A66 Northern Trans-Pennine Project

4.5 Statement of Common Ground North Yorkshire County Council and Richmondshire District Council (Rev 2)

24 January 2023

**4.5 JOINT STATEMENT OF COMMON GROUND WITH
NORTH YORKSHIRE COUNTY COUNCIL AND
RICHMONDSHIRE DISTRICT COUNCIL**

INSET 4

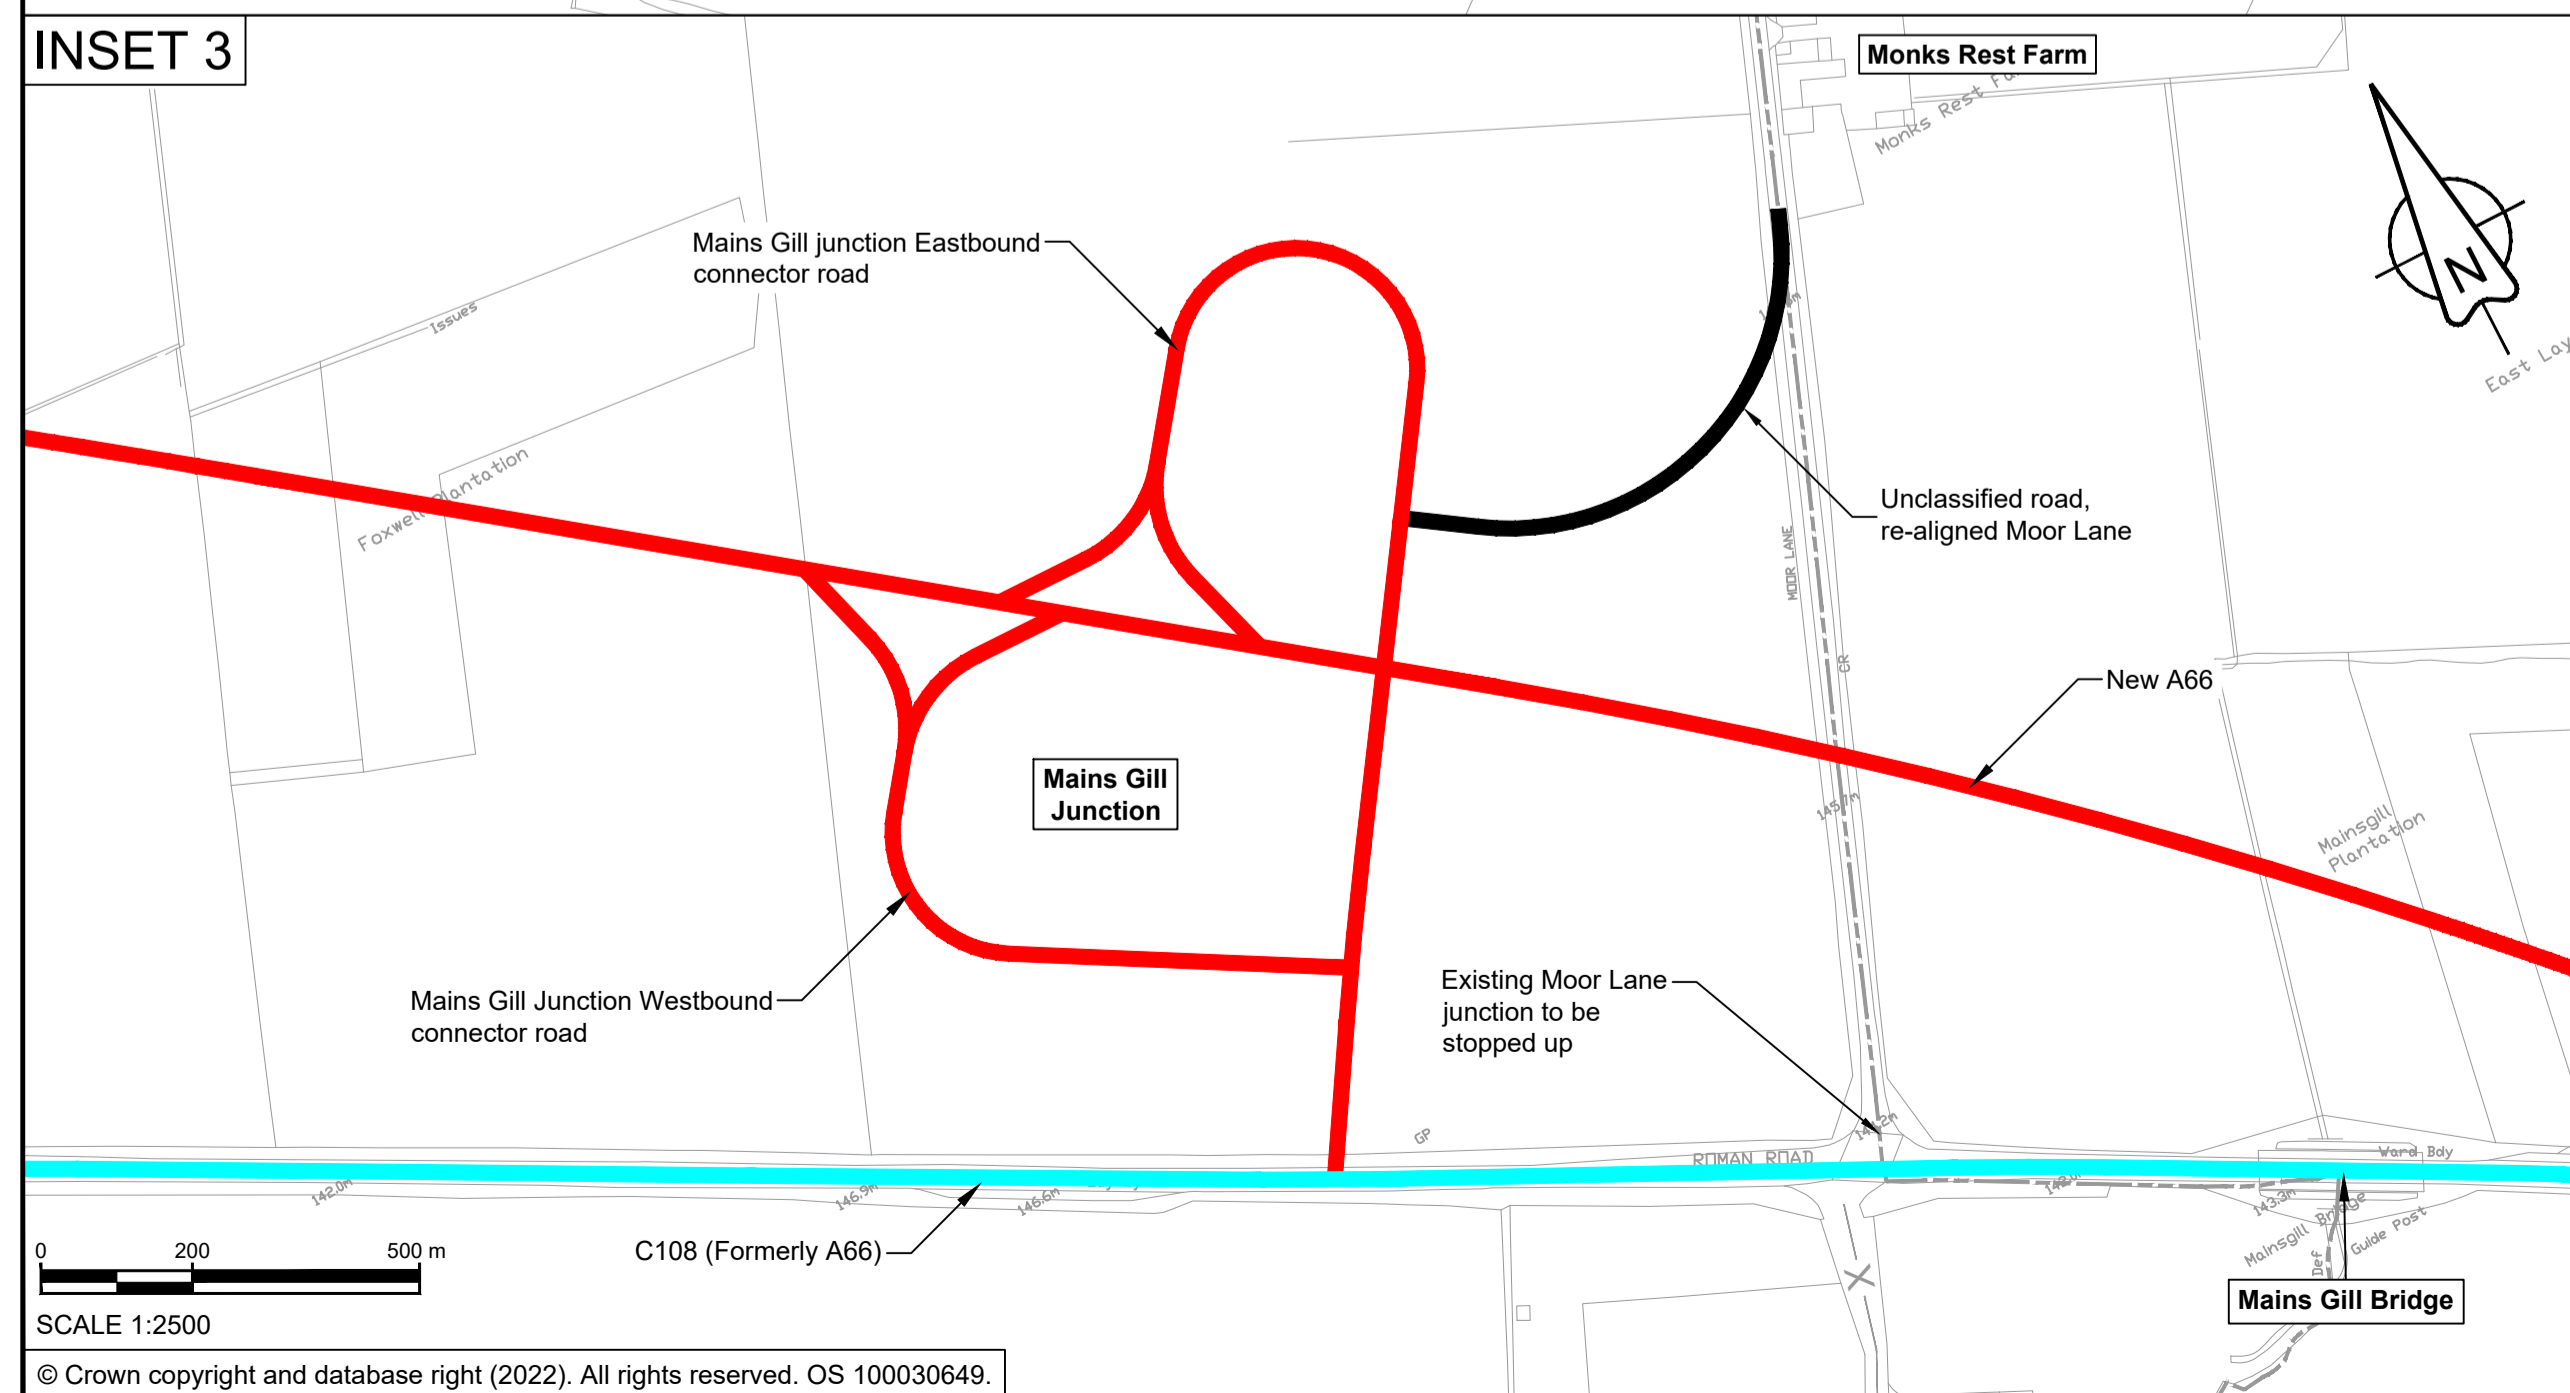
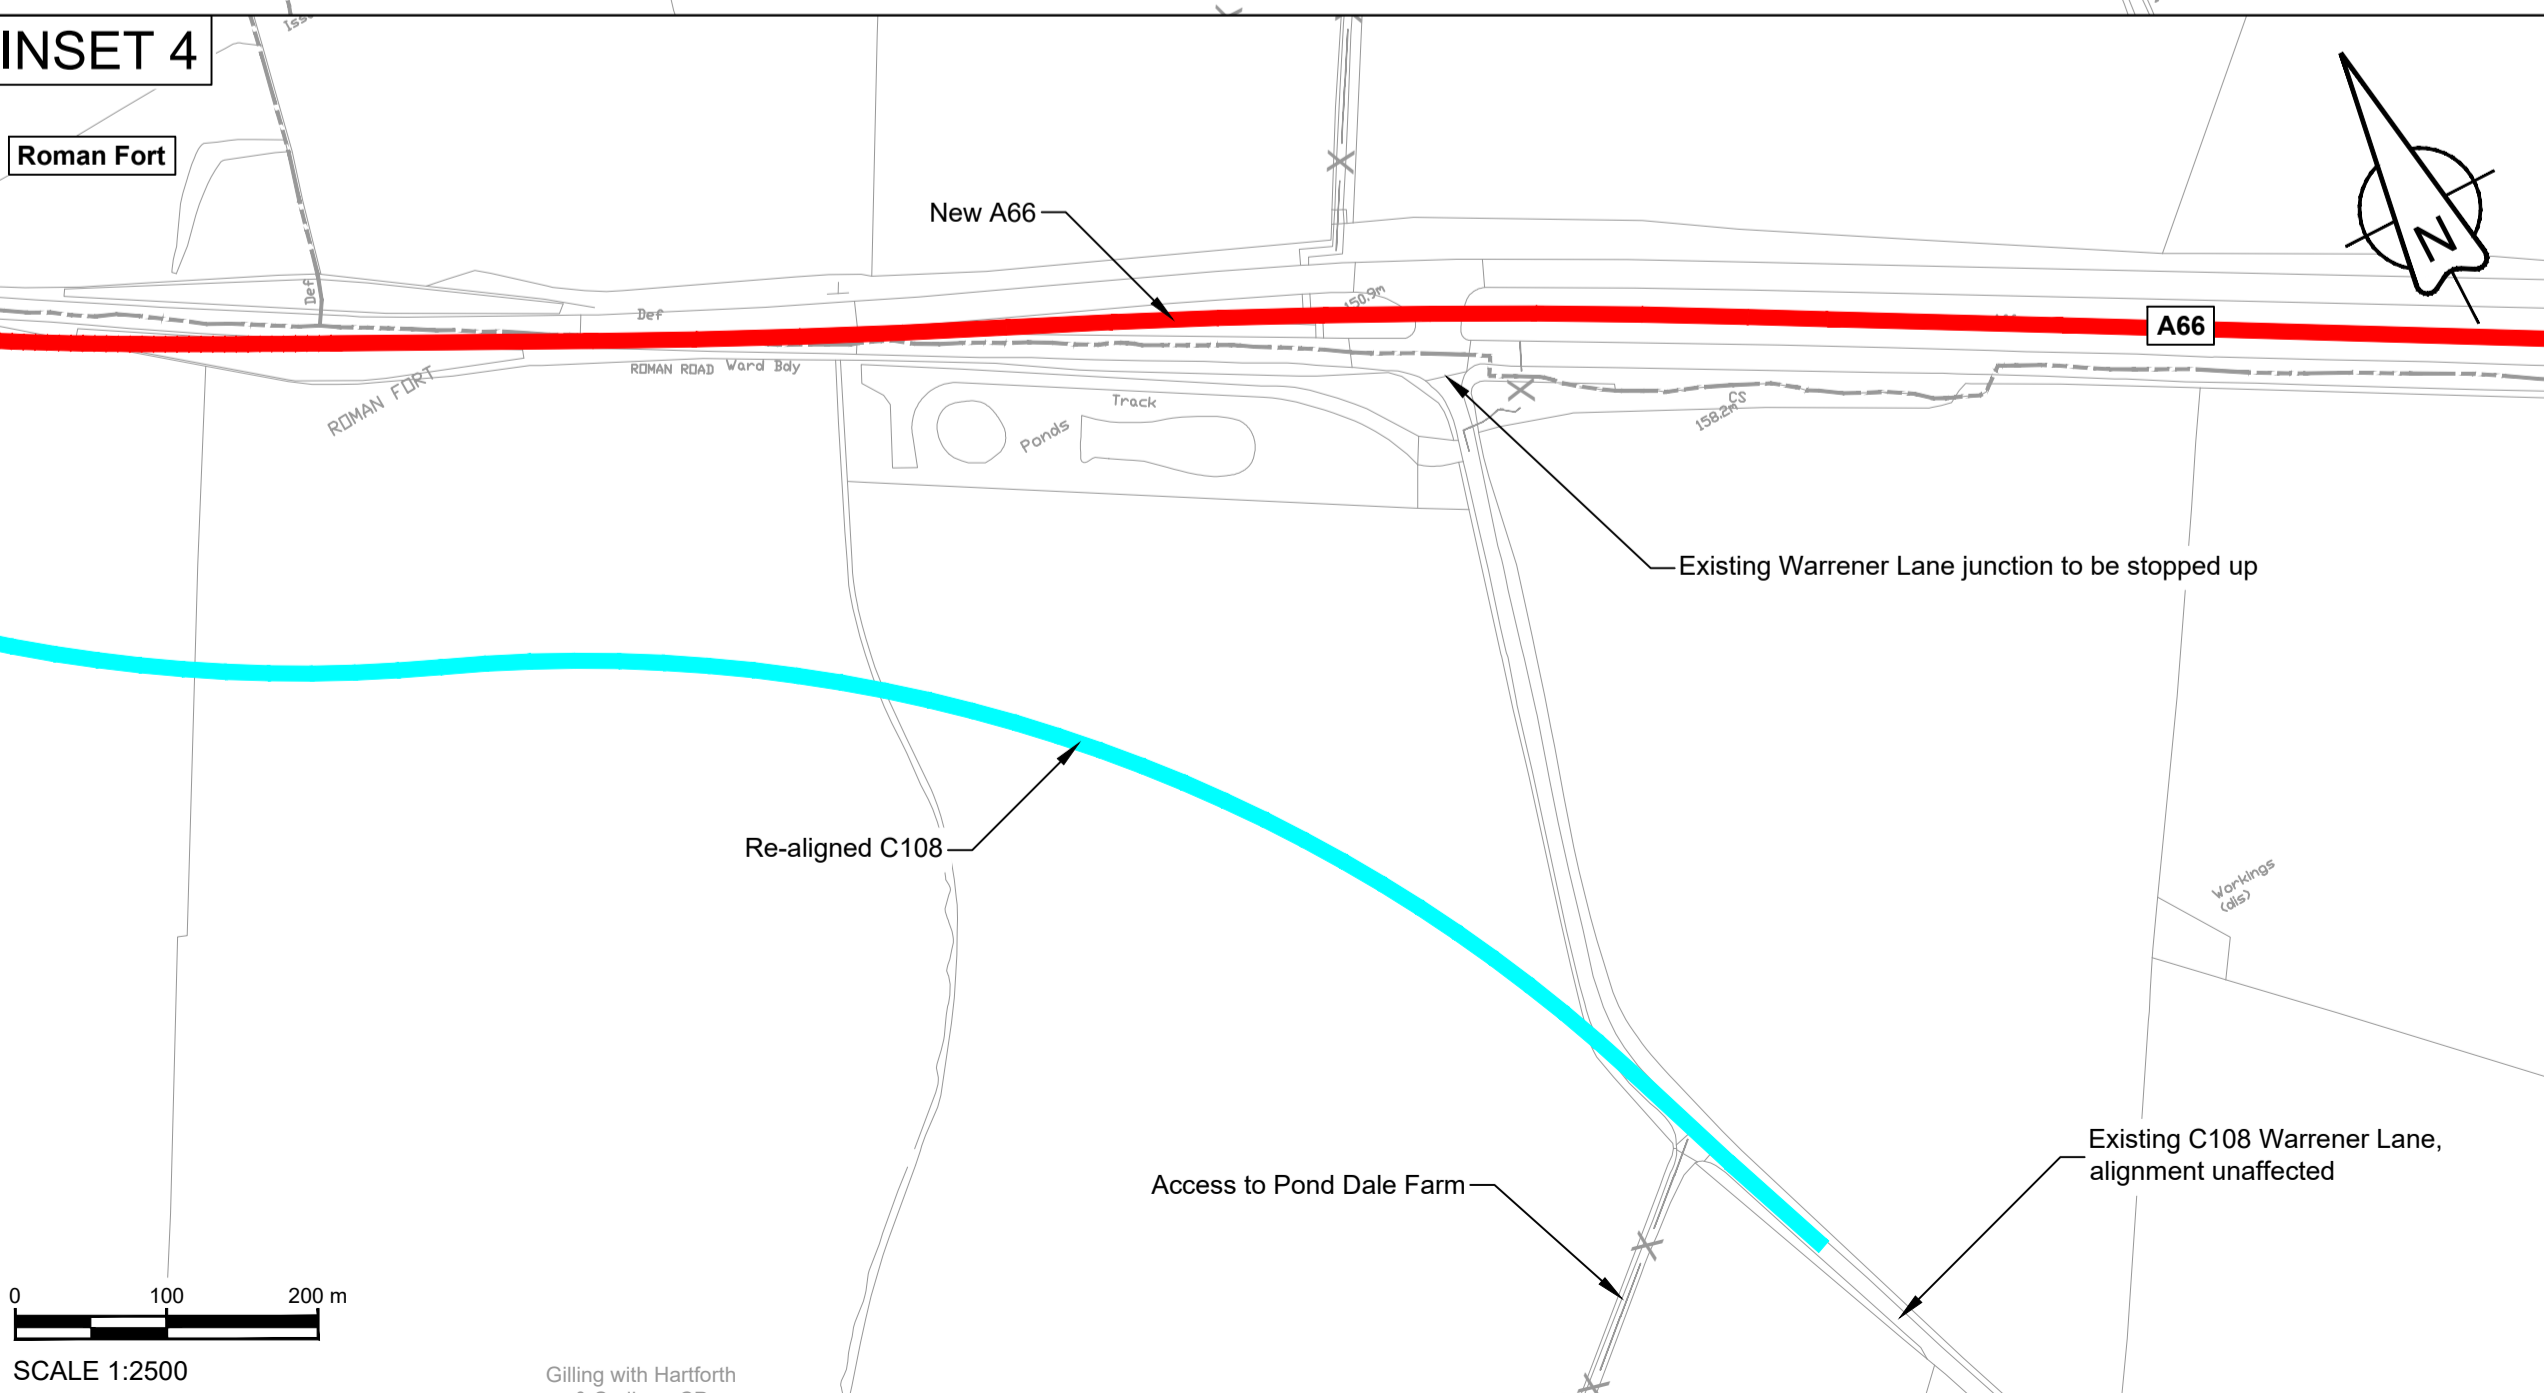
<p>3-2.14. Classification of Roads Plan</p>	<p>North Yorkshire CC & Richmondshire DC: Design Drawing Review Session</p>	<p>NYCC are happy with the C1108 and the extension of Warrener Lane, but we will seek to confirm with the team to ensure we are happy with this convention prior to those appearing on the schedules.</p>	<p>We will continue to seek confirmation on this matter.</p>	<p>Under discussion</p>	<p>13.06.2022</p>
<p>3-2.15. Traffic Regulation Order (Speed Limits) Plans:</p>	<p>North Yorkshire CC & Richmondshire DC:</p>	<p>Warrener Lane would that new stretch be at 50mph and will this leave us with an issue as to when</p>	<p>We will continue to seek confirmation on this matter.</p>	<p>Under discussion</p>	<p>13.06.2022</p>

3-1.7. Classification of Roads Plan: Moor Lane (and other Unclassified Road) junctions to the National Highway	North Yorkshire CC & Richmondshire DC: Design Drawing Review Session	Concern for Moor Lane (and other unclassified roads) what standards will these be built to. Issues previously where the access is to a high standard before hitting a smaller, unclassified road. This may need to be a departure to make this a narrow road.	The junction at Moor Lane would be built to a NYCC Design Standard rather than to DMRB to address this concern. This was the position agreed prior to submission of the DCO and will be integrated into the detailed design of the scheme.	Agreed	24.01.2023
